2023/0992

2 Medway Close, Barugh, Barnsley, S75 1NY

Detached outbuilding to be used as beauty/aesthetics salon and family room (Retrospective).

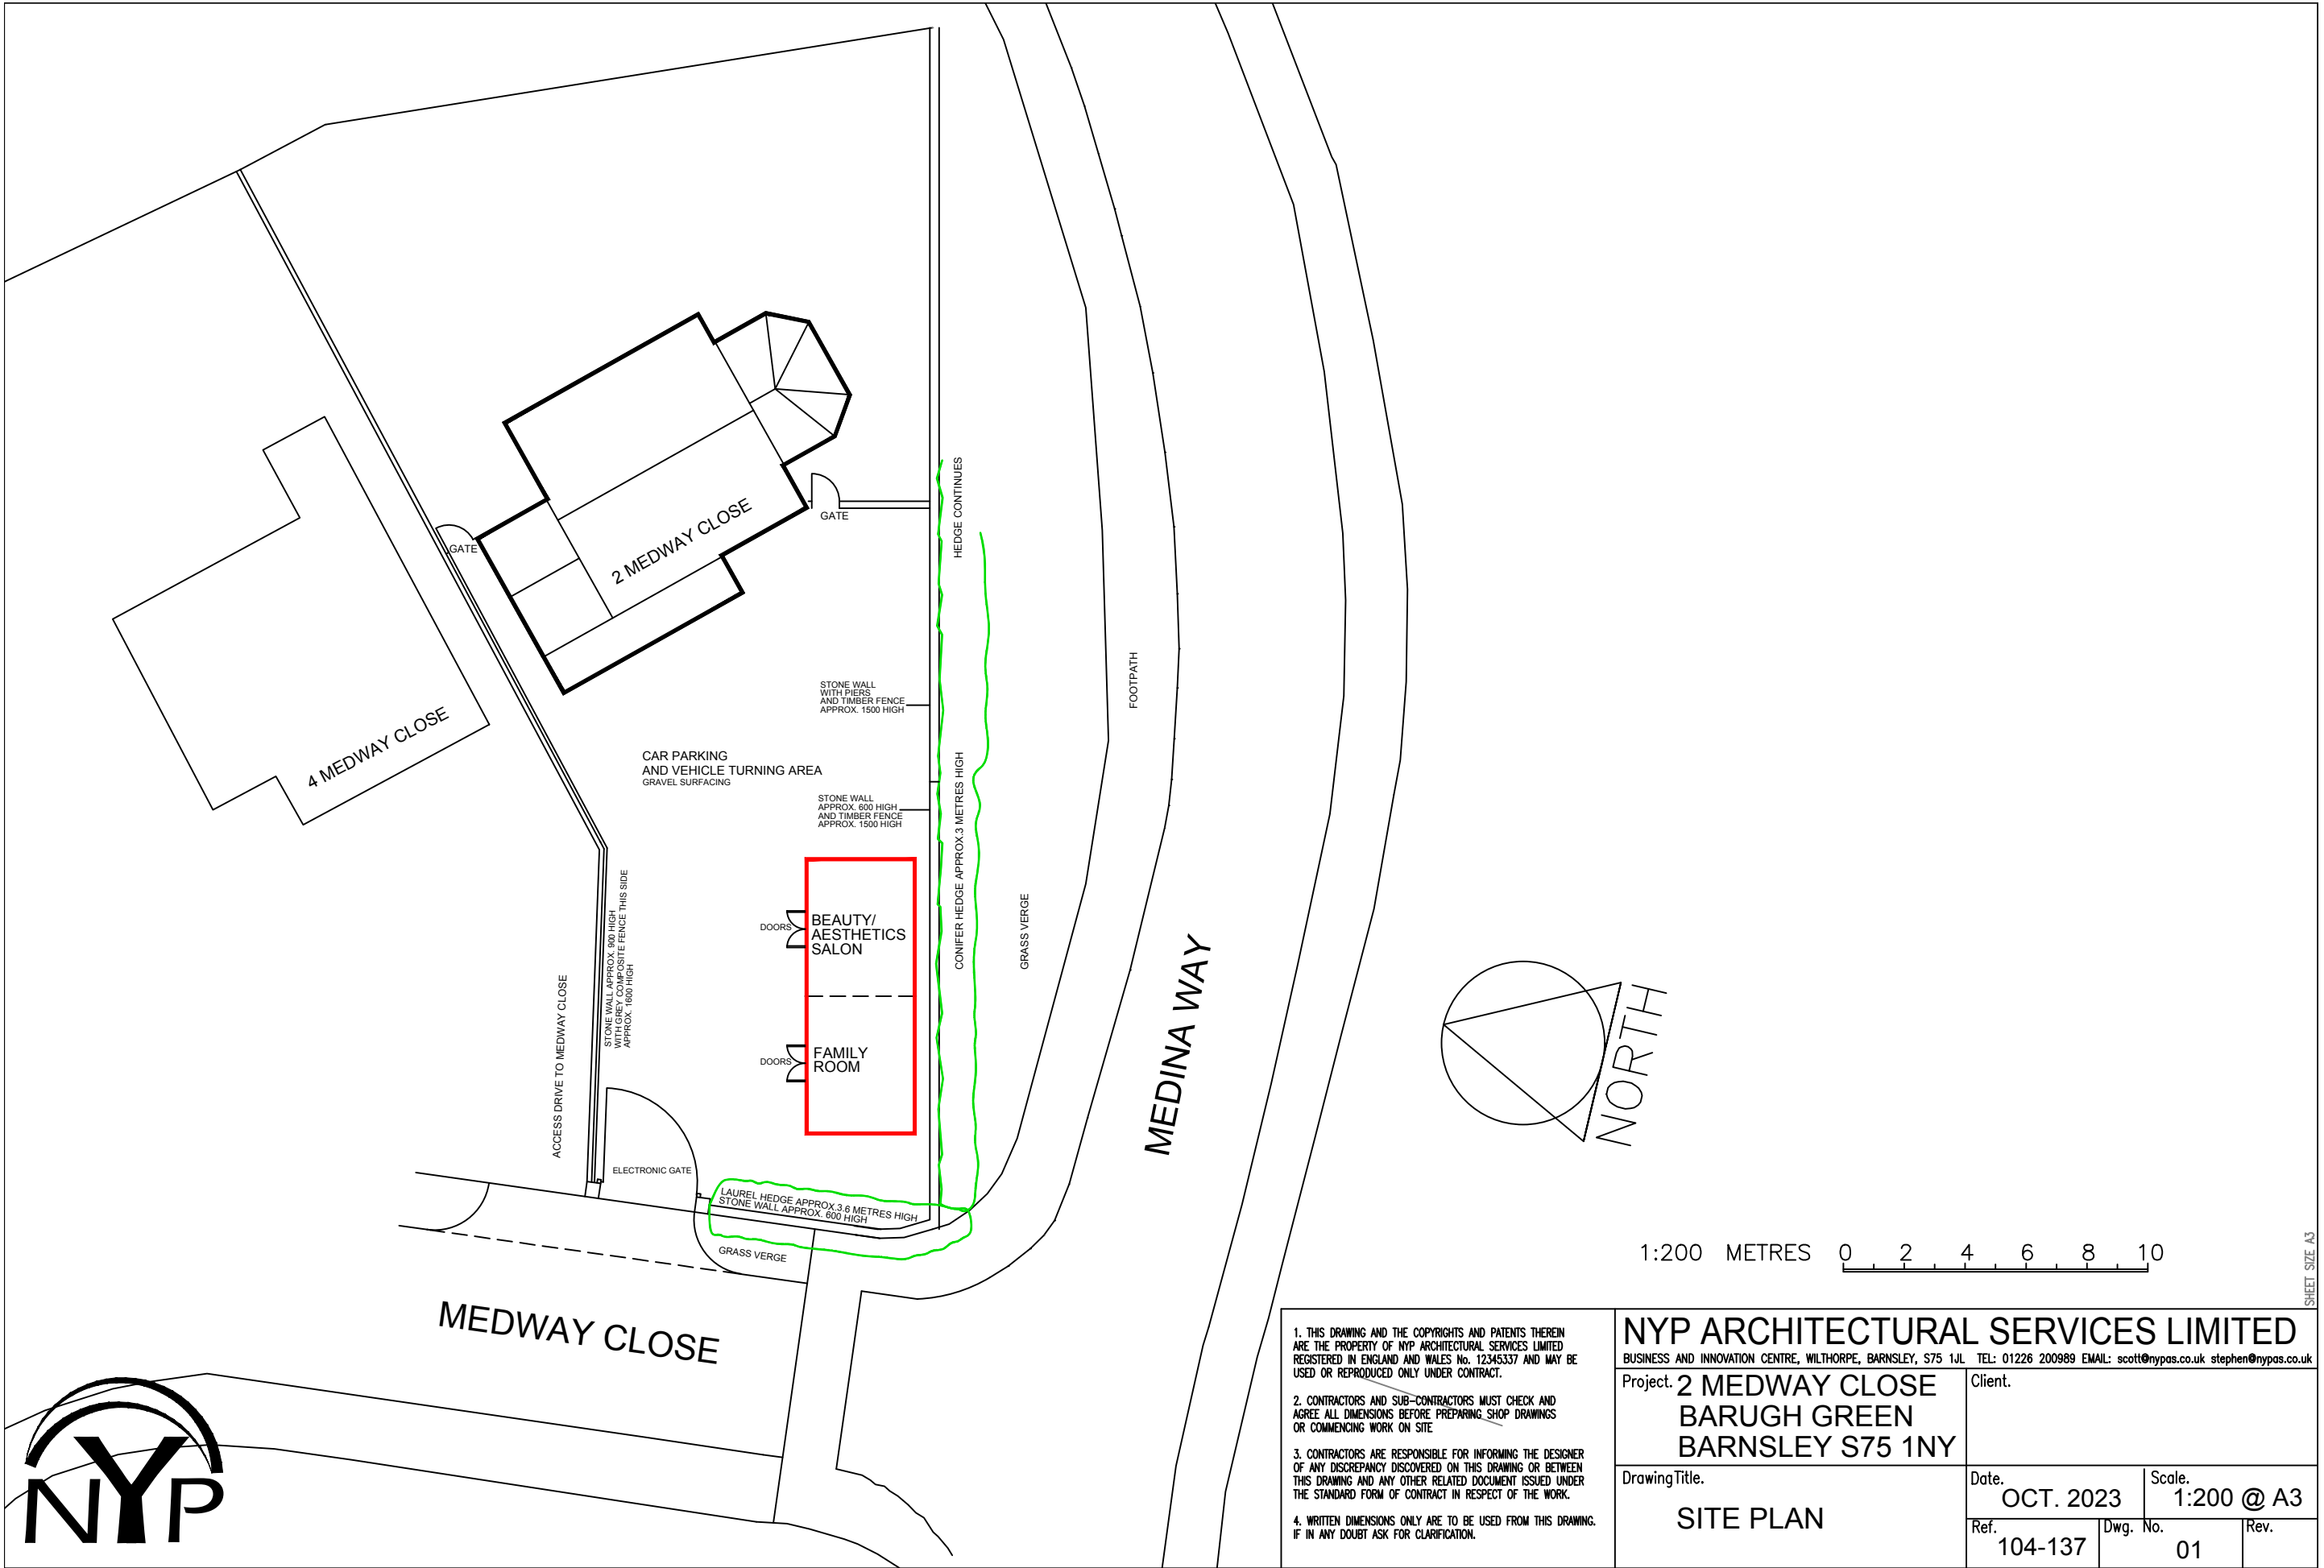
The main concern with the development is that it is not in accordance with the SPD. It is set forward of the principal elevation of the host property, partially visible from the public realm of the principal highway and adopts external materials and a roof form that are not sympathetic to the character of the host property or broader street scene. However, the outbuilding is located to the south-west corner within the plot and is suitably screened by existing high hedges. The outbuilding adopts a relatively restrained roof height and footprint. An existing separation distance between the outbuilding and the host property, and the orientation of the outbuilding is considered to lessen its significance and prominence. As such, it is not considered that the outbuilding would significantly

A condition will be applied to any forthcoming decision whereby the hedge within the curtilage of the application site on the northern boundary would be retained.

A minimum of 5 no. parking spaces is expected to be provided within the curtilage of the host property. This provision would comprise two spaces maintained for residential use and three additional spaces for the business.

It is not expected that the driveway would function at full capacity as appointments are and would continue to be made on a 1:1 basis. Nevertheless, the driveway could accommodate the required minimum number of spaces if needed.

Highways DC were consulted on the application. It was agreed that the level of parking that could be accommodated by the application site would be adequate. However, a concern was raised regarding existing surfacing materials, stating that to be suitable for any intensification of use, all areas used by vehicles must be surfaced in a solid bound material. Whilst this concern is acknowledged, there is no restriction as to the type of surfacing material that could be used to surface a driveway provided that the material would be porous, or provision is made to direct run-off water from the hard surface to a permeable or porous area or surface within the curtilage of the dwellinghouse in line with the remit of the Town and Country Planning (General Permitted Development) (England) Order 2015.

Drawing Title. BEAUTY/AESTHETICS SALON
AND FAMILY ROOM
PLAN AND ELEVATIONS

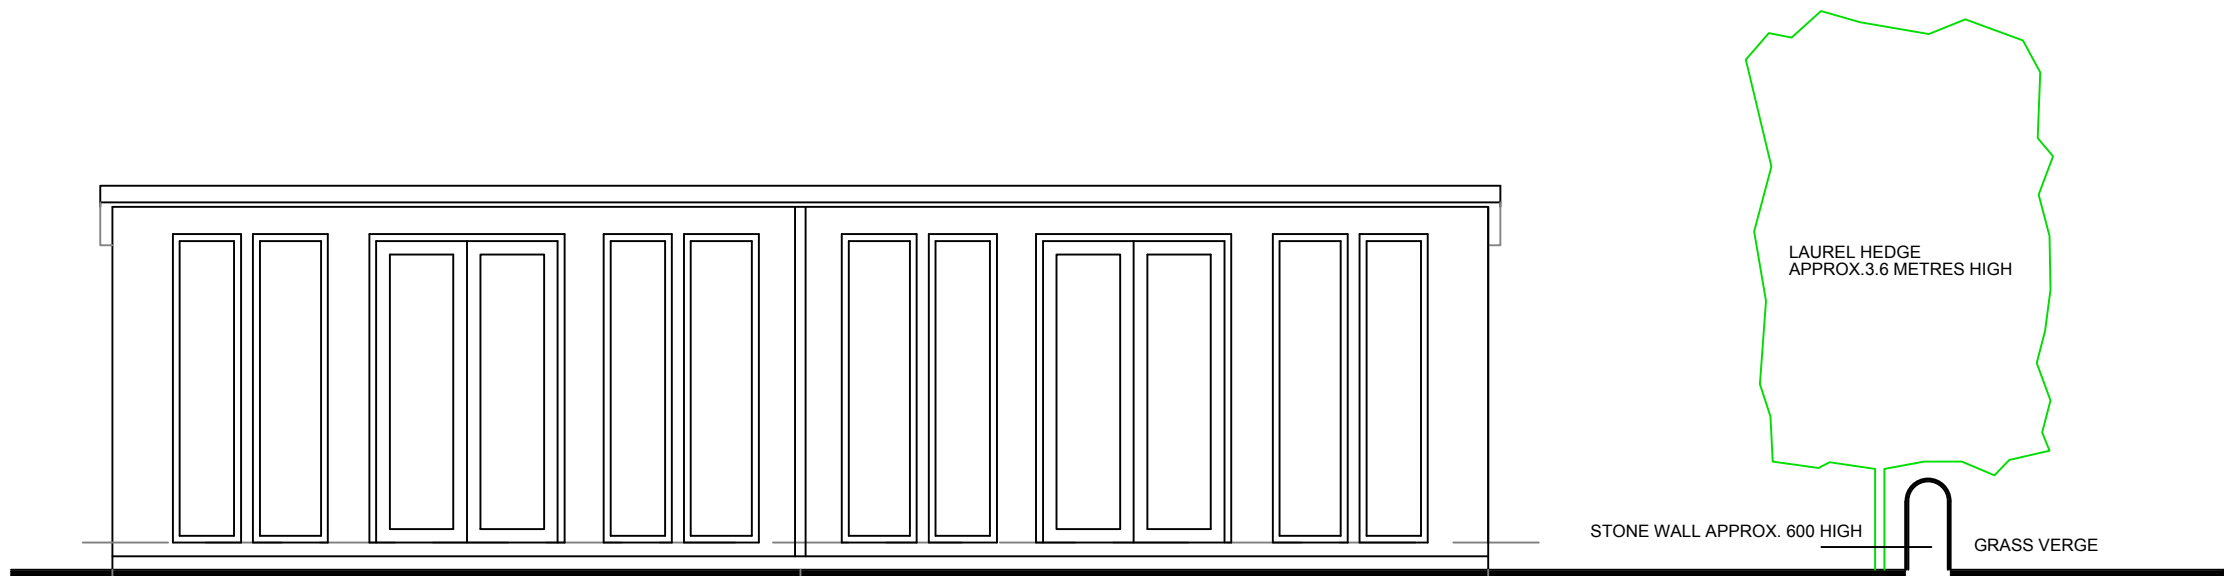
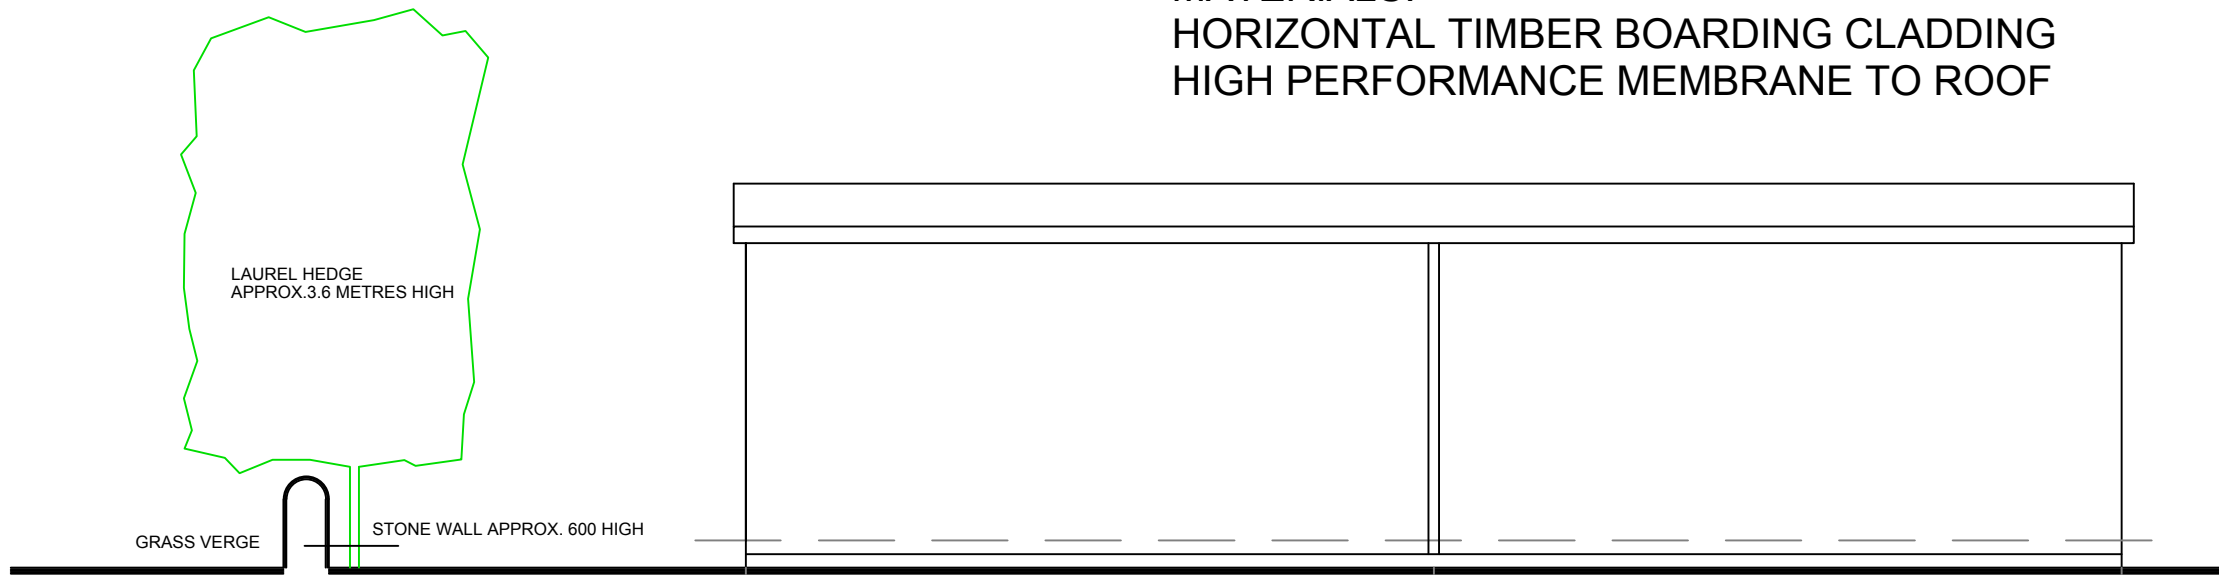
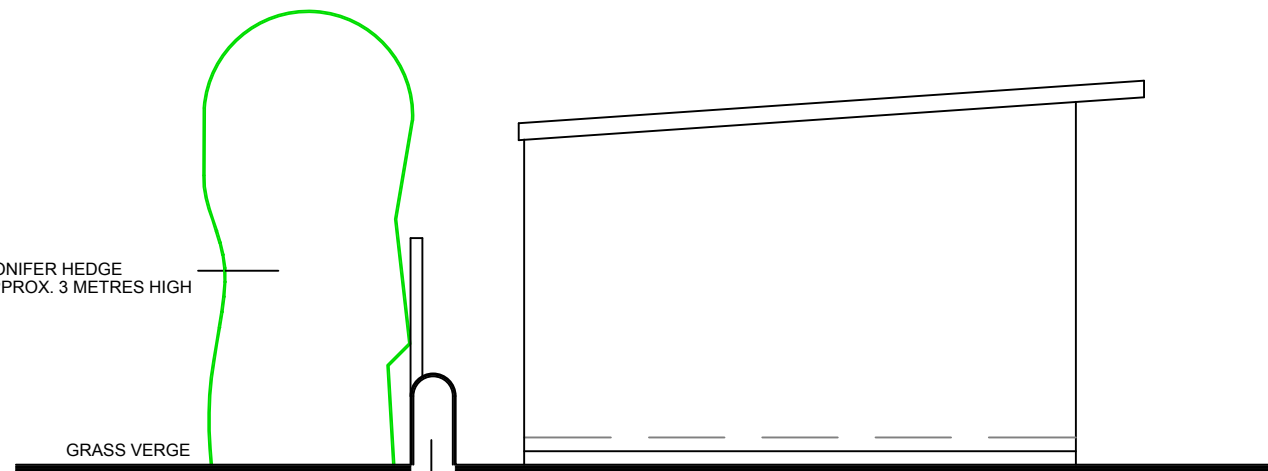
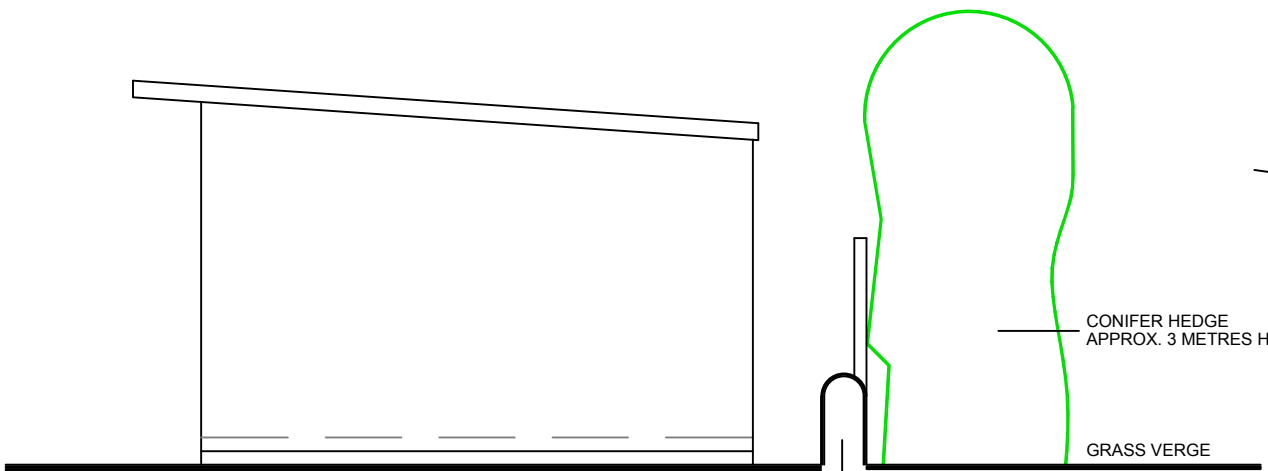
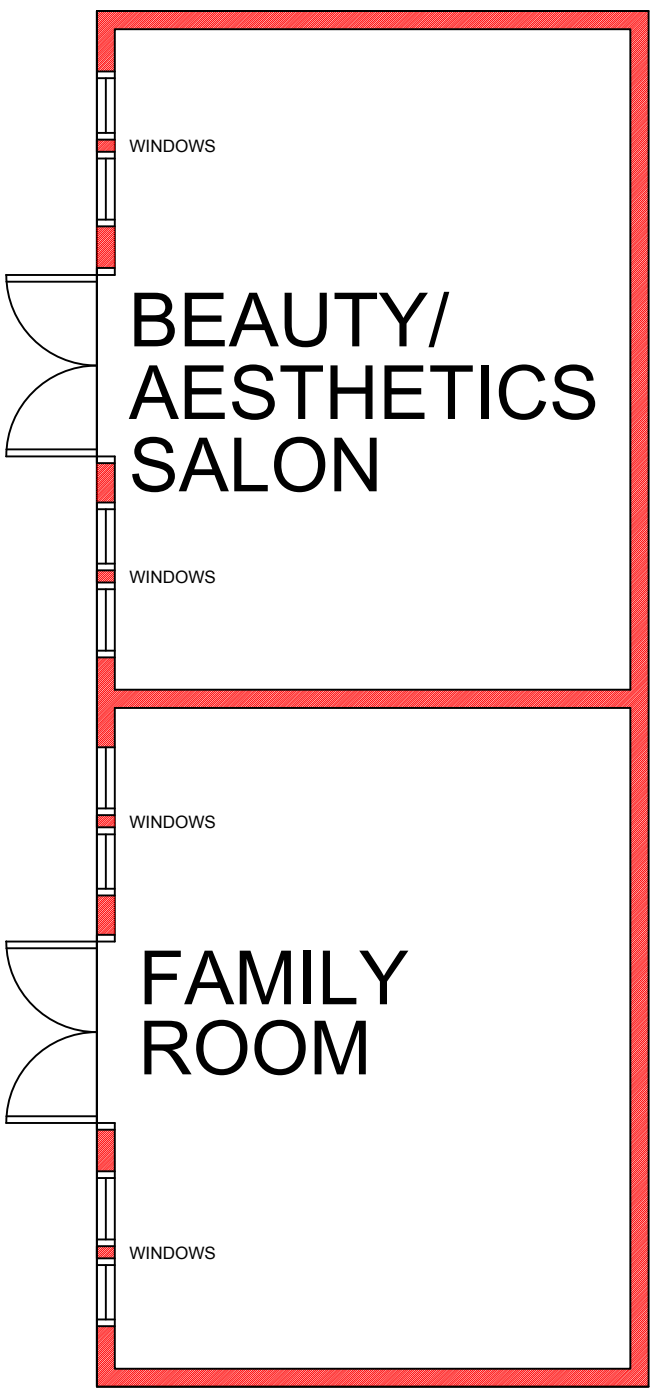
The outbuilding measures approximately 3.65 metres in width by 9.1 metres in length, comprising approximately 14.84m² of internal floorspace used as a beauty salon and 14.89m² used as a family room. The outbuilding adopts a slightly sloped flat roof and is clad with horizontal timber boarding.

The retrospective proposal is therefore not considered to be overly prominent nor dominant and does not significantly detract from the character of the host property or the broader street scene.
